### **Code Enforcement Comments:**

### **Carl's comments:**

**DRB SUBMITTAL**  
DATE: MAY 18, 2020 ORB # 18-236  
**A1.10**  
SITE PLAN - DRB

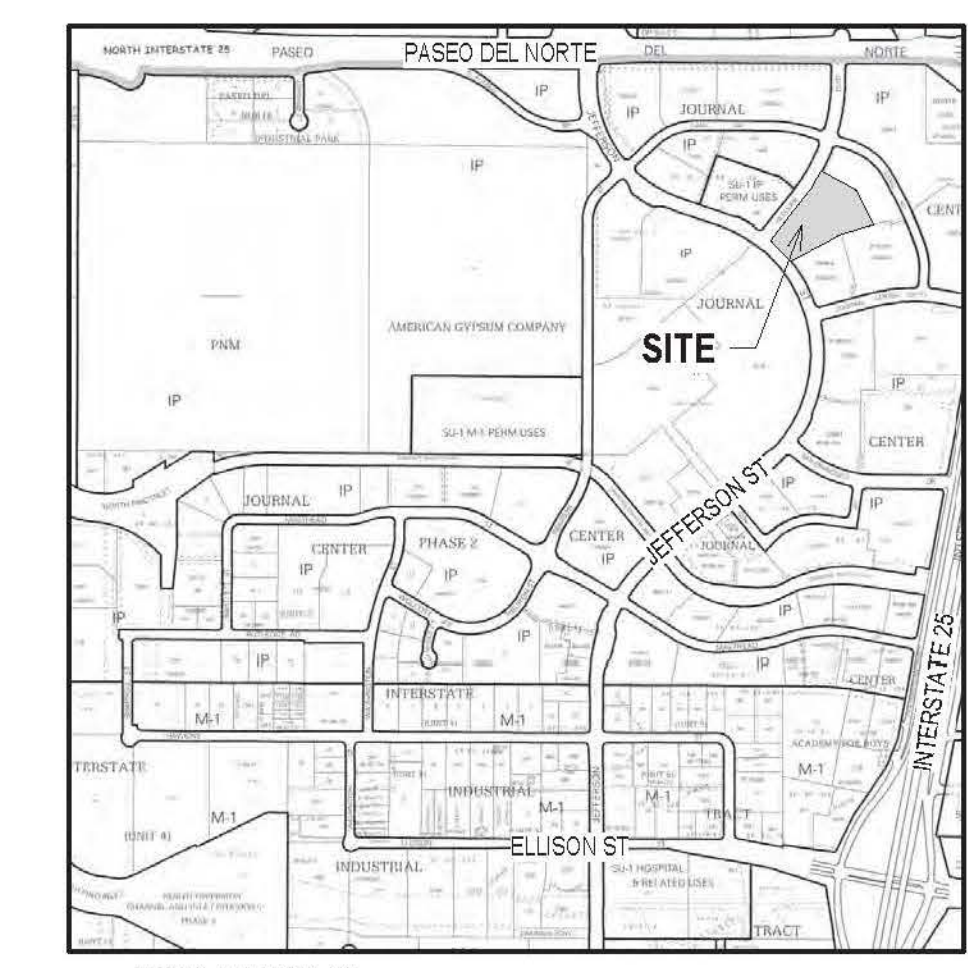
*If the decision is left to Planning, according to the section above, the Planning Director may approve a reduction of parking requirements if the study provides a more accurate measure than any standards in section 5-5 that would apply.*

*Code does not oppose this request, we recommend that all other standards in the IDO be exhausted prior to pursuing this request.*

*As per Table 6-4-2 Allowable Deviations, a 5% Deviation for minimum off-street vehicle parking spaces may be requested. A 5% reduction would be 11 spaces leaving 226 required spaces. The 23 parking space difference would then be reduced to a 12 parking space difference.*

*This section also applies: 5-5(C)(5)(d) 2. Electric Vehicle Charging Station Credit, When a new parking lot containing more than 200 off-street spaces is constructed, at least 2 percent of the vehicle parking spaces shall include electric vehicle charging stations with a rating of 240 volts or higher. This will also reduce the number of spaces from 12.*

*Another reduction the customer may seek is, Van and Car Pool Parking Credit*

*5-5(C)(5)(e).*

*If none of these reductions are possible, I would then state there is possible a case for approving the parking reduction requirement.*

*A concern from a Code enforcement position is setting precedence and making an approval based on a future Premium Transit designation under the comp plan. This is currently not in a Premium Transit Corridor according to the current IDO.*

*The proposal also mentions collective transit route times of 15 minutes – the IDO does not currently recognize collective peak time frequency.*
